From: Charlotte Burrows [Charlotte.Burrows@arun.gov.uk]
Sent: 07 October 2014 16:10
To: 'pamela may'
Subject: RE: 172A Pagham Road, Pagham - P/87/14/HH
Attachments: P8714HH.pdf

I have been advised that you are assisting Mr Ciccone with the submission of his application. There is a query regarding the red edging of the Location and Block plan, unfortunately we don't have your phone number so would you please either phone or email me just so I can confirm something with you.

SITE PLAN

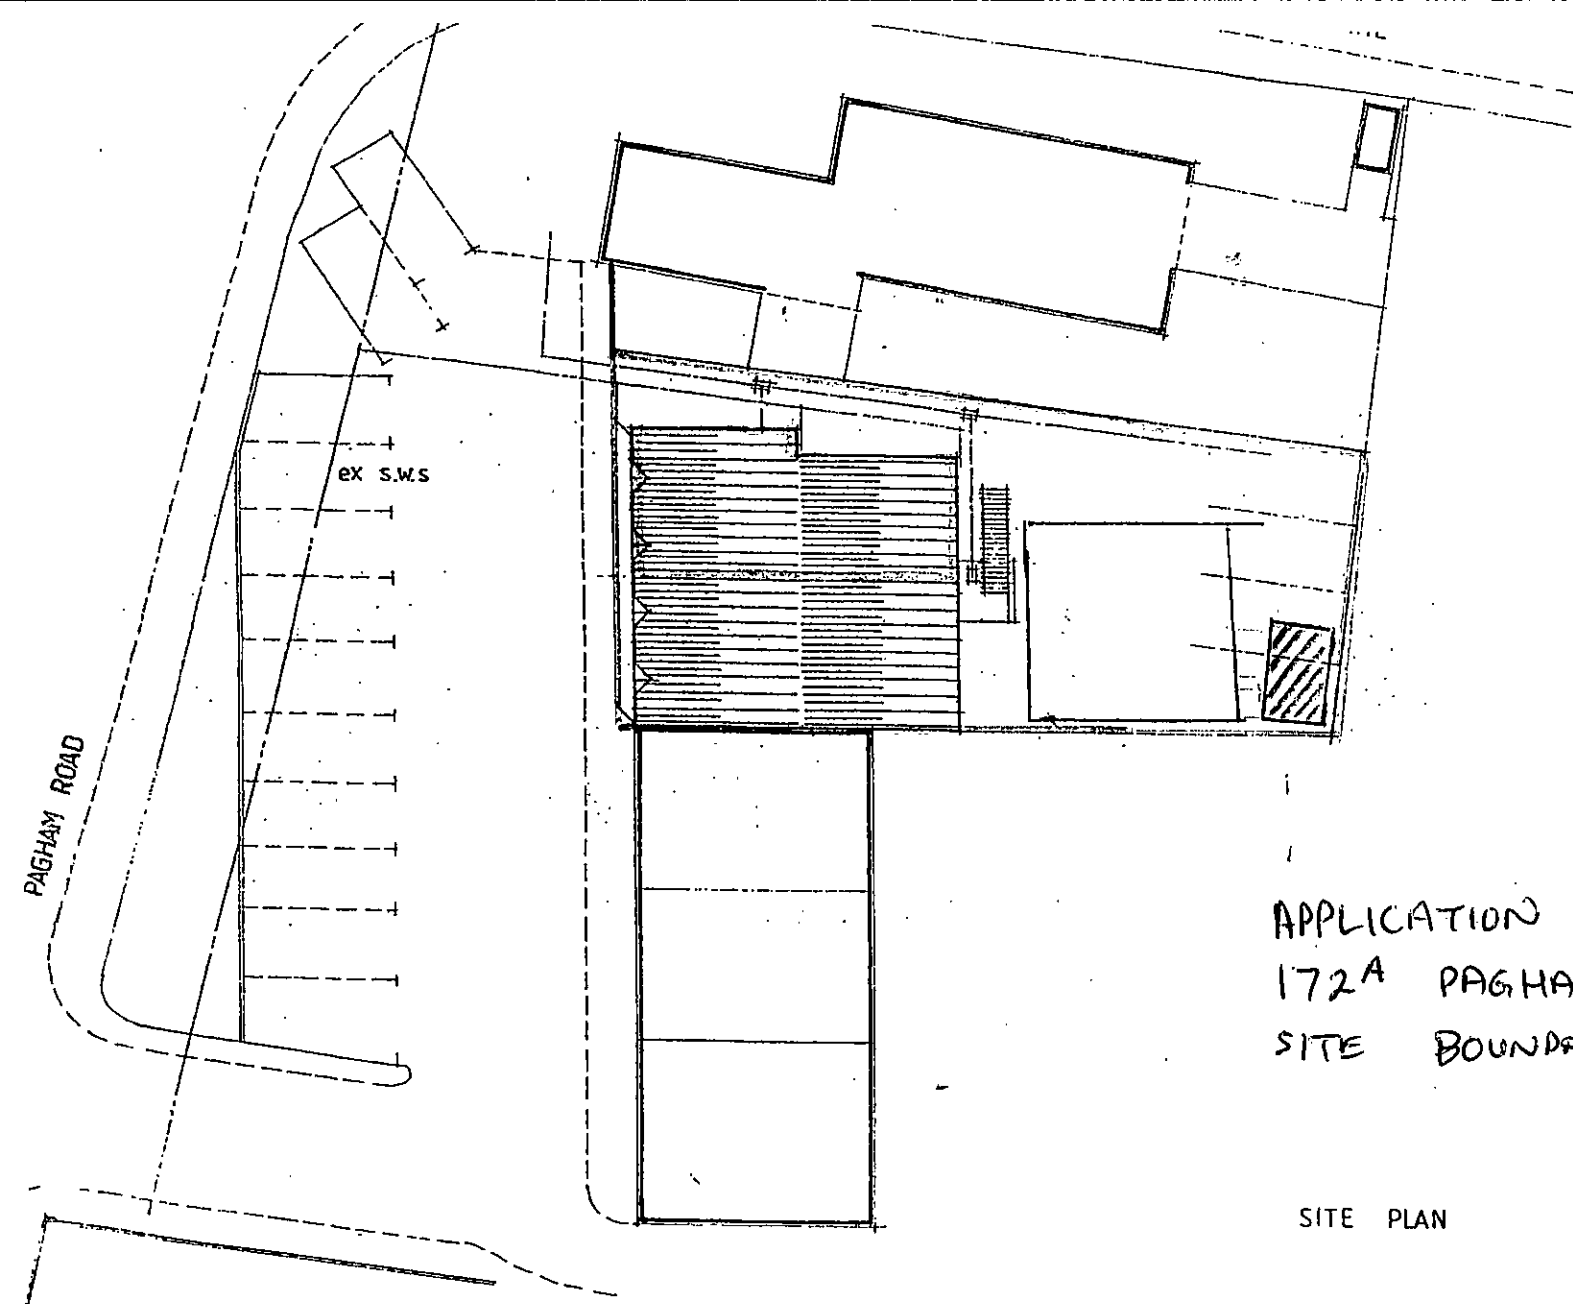
I have attached the Location plan that's requires the red edge to be amended. Are you able to make the amendment and then email back to me please.

Have been back to the property and the edge should be straight.
